Spen Valley District Scout Council  
Fan Wood Camp Site  
Ferrand Lane  
Gomersal  
Cleckheaton  
BD19 4DA

17<sup>th</sup> November 2023

**Land to the rear of 271 Cliffe Lane, Gomersal, BD19 4SB.  
Demolition of existing dwelling and erection of 87 dwellings.**

CLIENT	QUARTERS GOMERSAL
PROJECT	CLIFFE LANE, GOMERSAL
TITLE	SITE PLAN LAYOUT
DRAWING NO.	1694-101
REVISION	F
SCALE	1:500 @ A1
DATE	01.23
DRAWN BY	BC
CHECKED BY	-

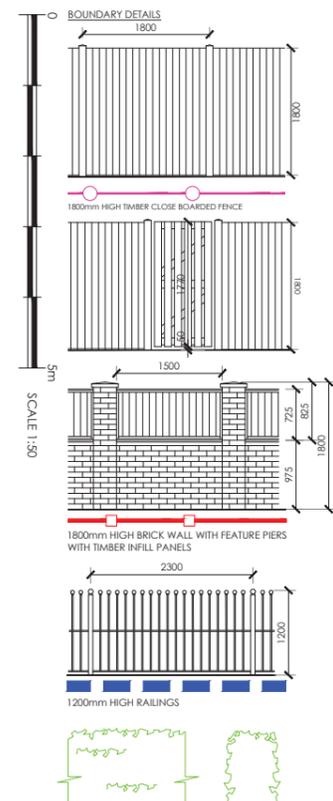
- The current proposal plans show one pedestrian access on to Ferrand Lane to the Northeast corner of the development. Can the Planners please confirm that this will be the only access onto Ferrand Lane and that there will be no vehicular access between the development site and Ferrand Lane.
- The current proposal plans show a buffer zone along the boundary to Ferrand Lane, can it be confirmed that this will not be built upon, in either this development or in the future, and will be maintained as a green space to help with wildlife habitat.
- As Ferrand Lane is an unadopted route, and is both narrow and un-even, with several bends having poor visibility, SVDSC would request that a secure fence, which cannot be climbed, be installed by the developer along the boundary of their site as a health and safety measure, to avoid pedestrian entering Ferrand Lane from any un-marked accesses.
